Submissions Report

Detailed State Significant Development Application
Site C, Crows Nest Over Station Development

Facade protrusion within Articulation Zone - Axonometric SE

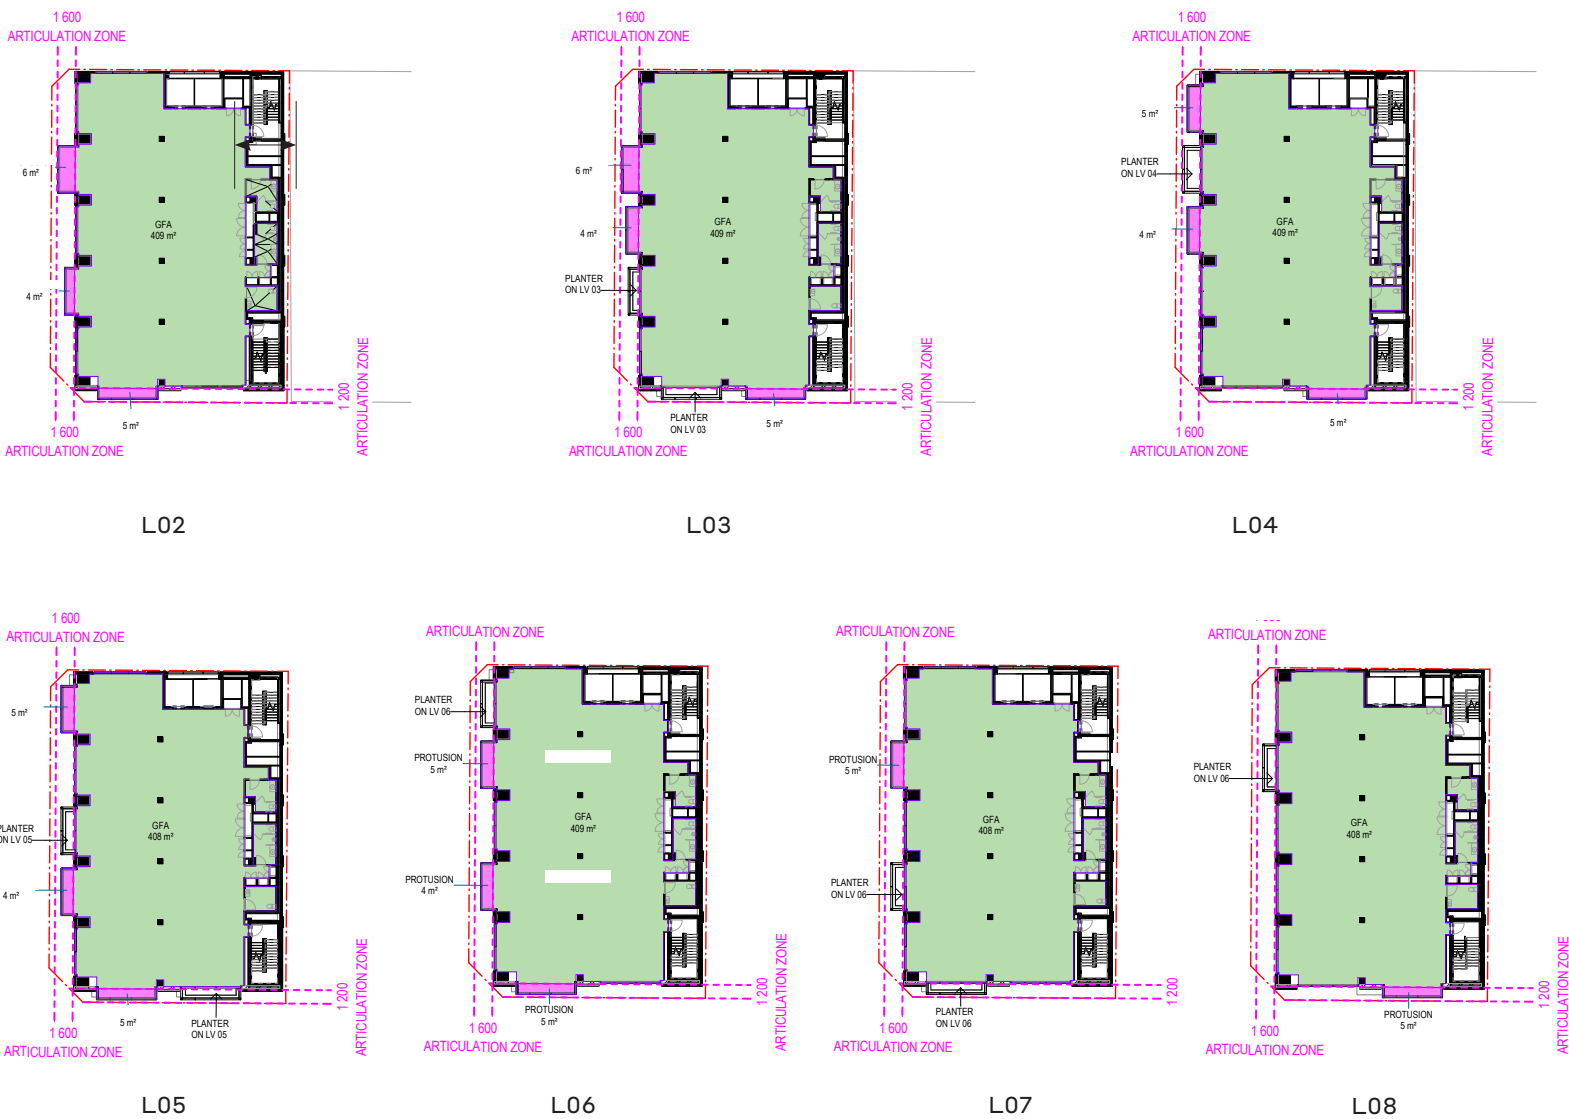
Extract	Response
<p>1. Roof Feature</p> <p>a. Demonstrate the proposal complies with Condition B5(c), including architectural roof feature within the articulation zones.</p> <p>Note: Condition B5(c) of the Concept application (SSD 9579) prescribes that built form must occupy no more than 25% of the total volume of the articulation zones.</p>	<p>Updated calculations are provided within the Articulation Zone Plan at Appendix A, capturing the components of the architectural roof feature and stair overrun that occur within the articulation zone at roof level. The calculations demonstrate that the proposed development complies with the requirements of Condition B5(c) of the Concept SSD Application. A total equating to 19.9% (592.83m³) of the volume of the articulation zones has been used by the proposed development. This is less than the 25% upper limit nominated by Condition B5(c) of the conditions of consent.</p>
